Our Ref: AL/49/21/DOC

Approval of details reserved by condition imposed under ref AL/64/20/PL relating to Condition Nos 5 - pre-commencement site meeting with Tree Officer, 6 - mitigation method statement, 7 - archaeology, 8 - Construction & Environmental Management Plan, 13 - detailed level survey, 14 - materials & finishes, 15 - details of all new screen walls & fences, 16 - landscaping, 18 - energy efficiency measures, 19 - covered & secure cycle parking spaces, 21 - broadband, 22 - charging of electric vehicles and 25 external lighting.

Springfield Hook Lane Aldingbourne PO20 3TE

Condition Number 16

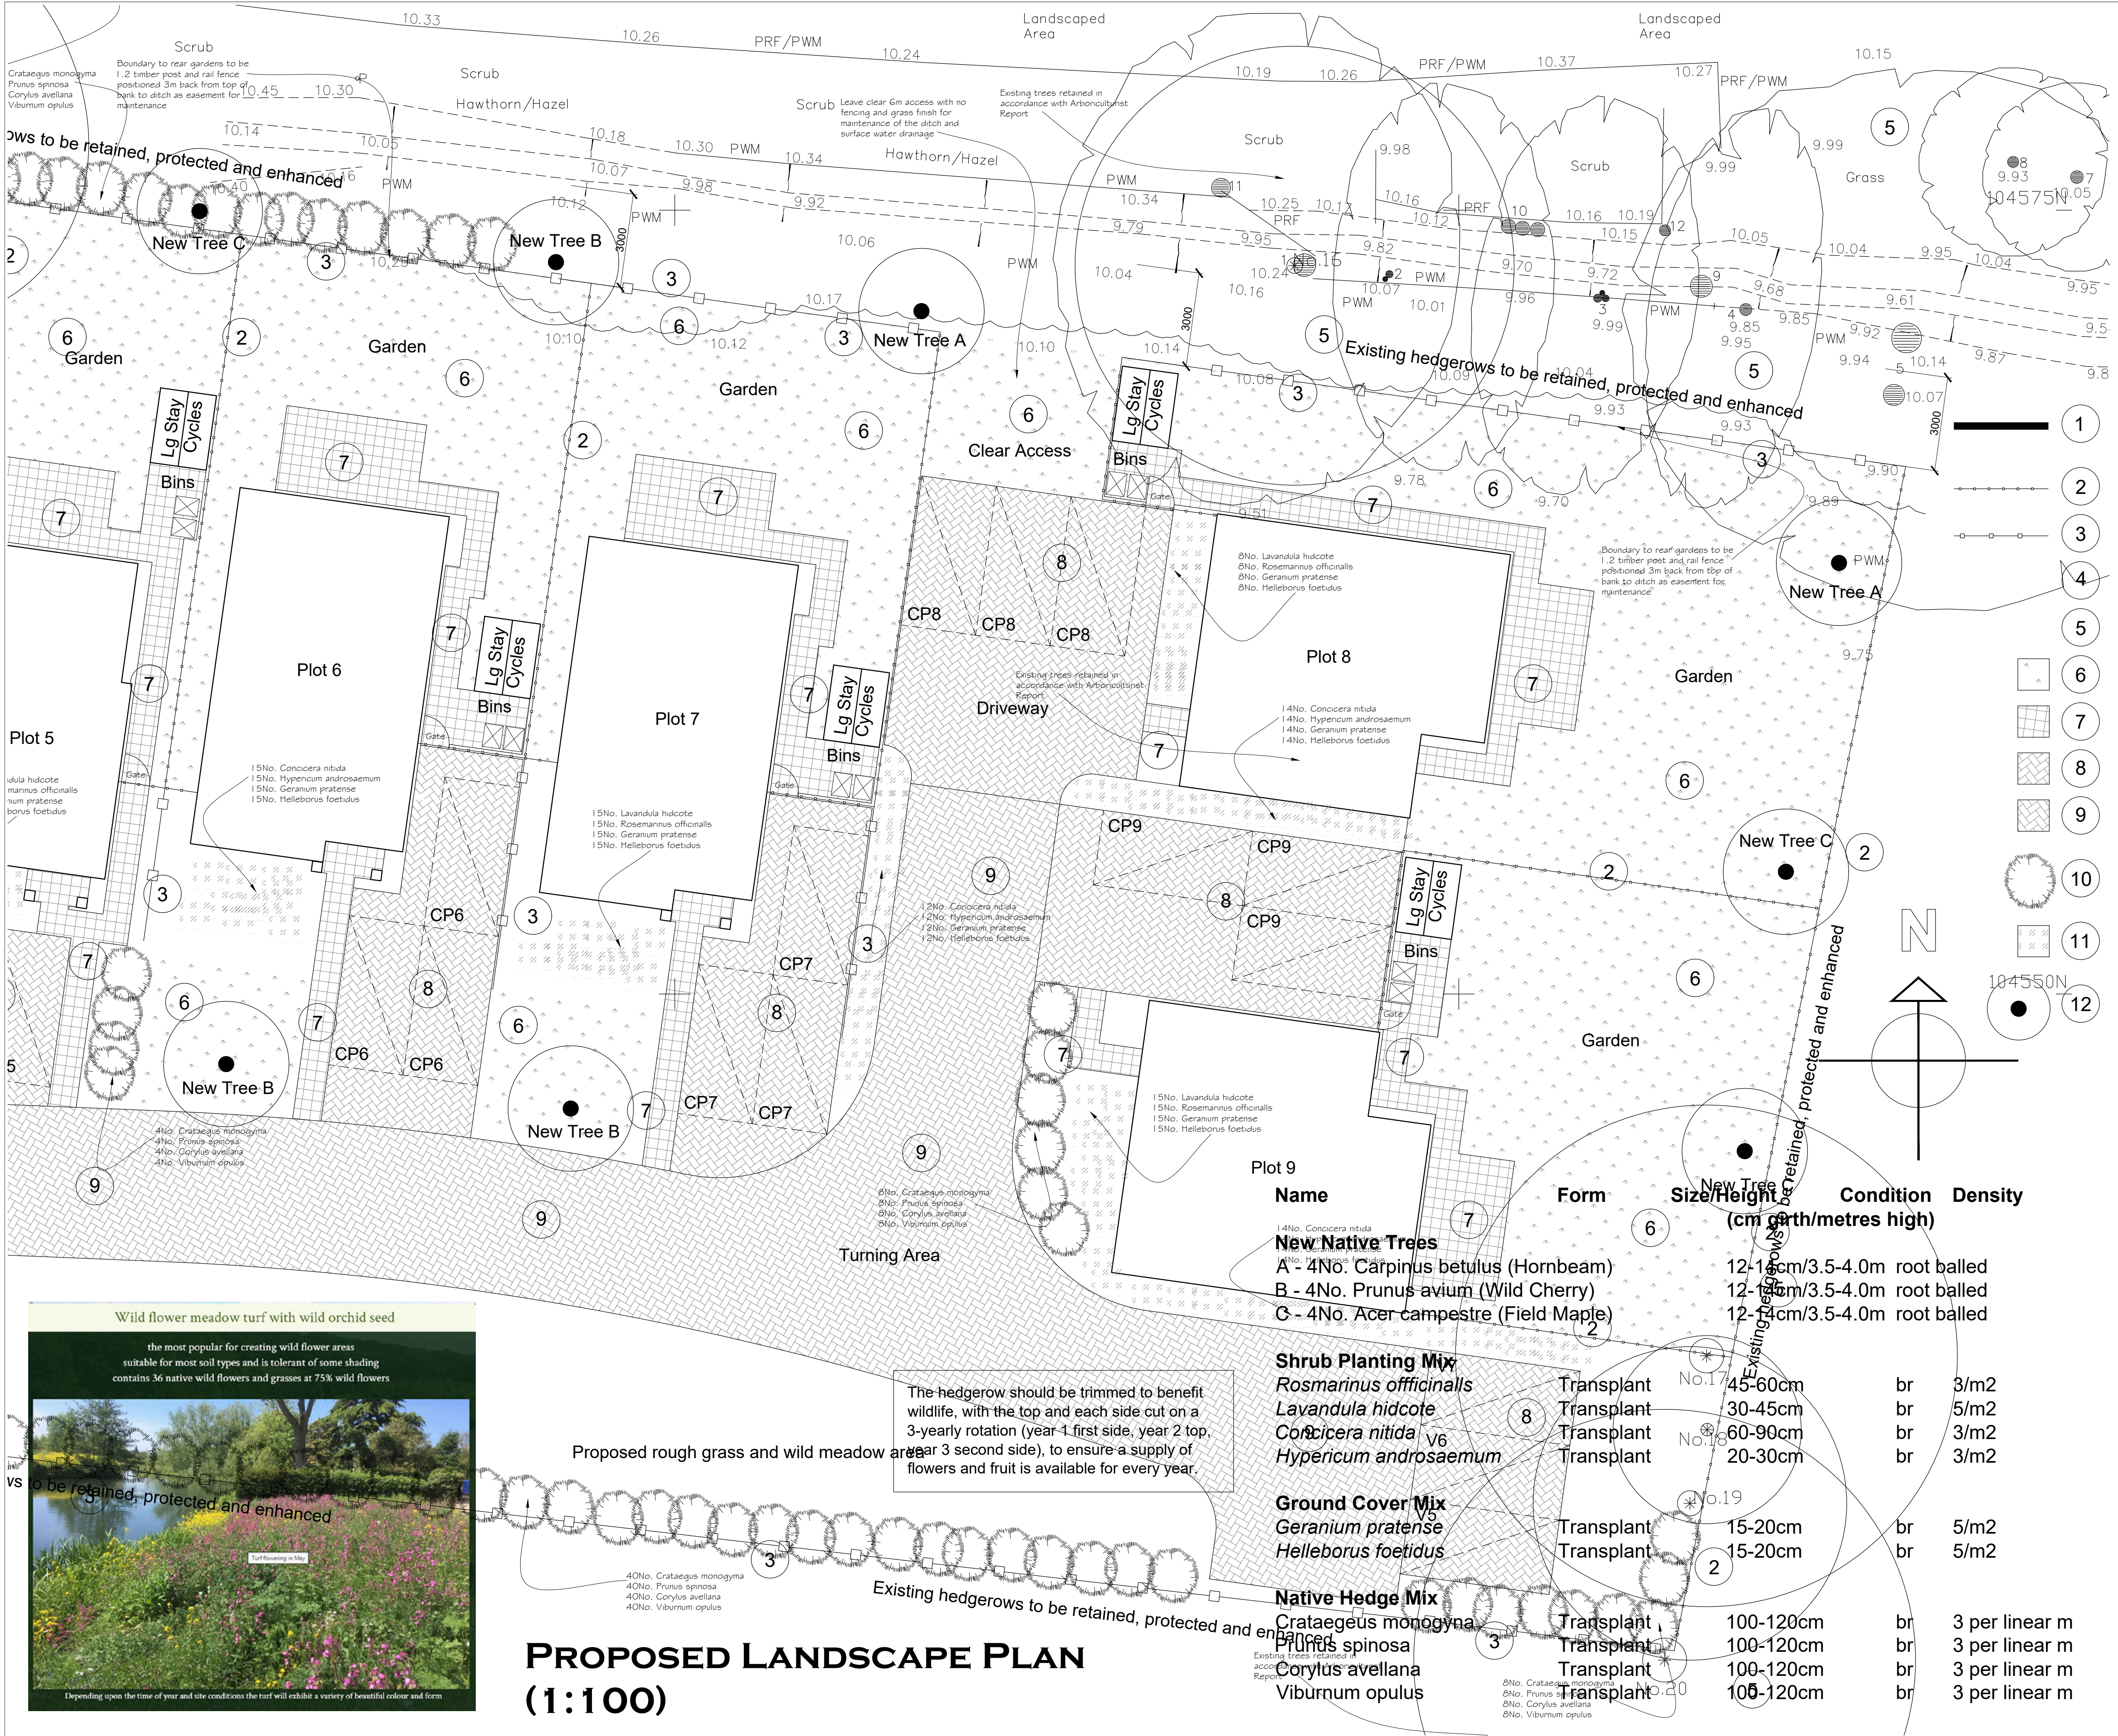
The submitted Landscape Scheme has been amended to show the actual quantities of the shrubs and hedging proposed as requested by the Councils Landscape Officer. However, the condition also specifically states that 24 new native trees will be required whilst only 12 are shown.

This 24 tree requirement was added to the standard wording of the condition to reflect the comments of the Councils Ecologist at the time of the application who requested that any trees to be lost be replanted on a 2:1 ratio to ensure biodiversity net gain (which itself is a policy requirement). Should this not be achievable then it would be necessary to explain why and/or provide additional biodiversity measures.

In the absence of the 12 extra trees or any justification as to why this cannot be achieved, it is not possible to agree the condition at this time and a resubmission will be required.
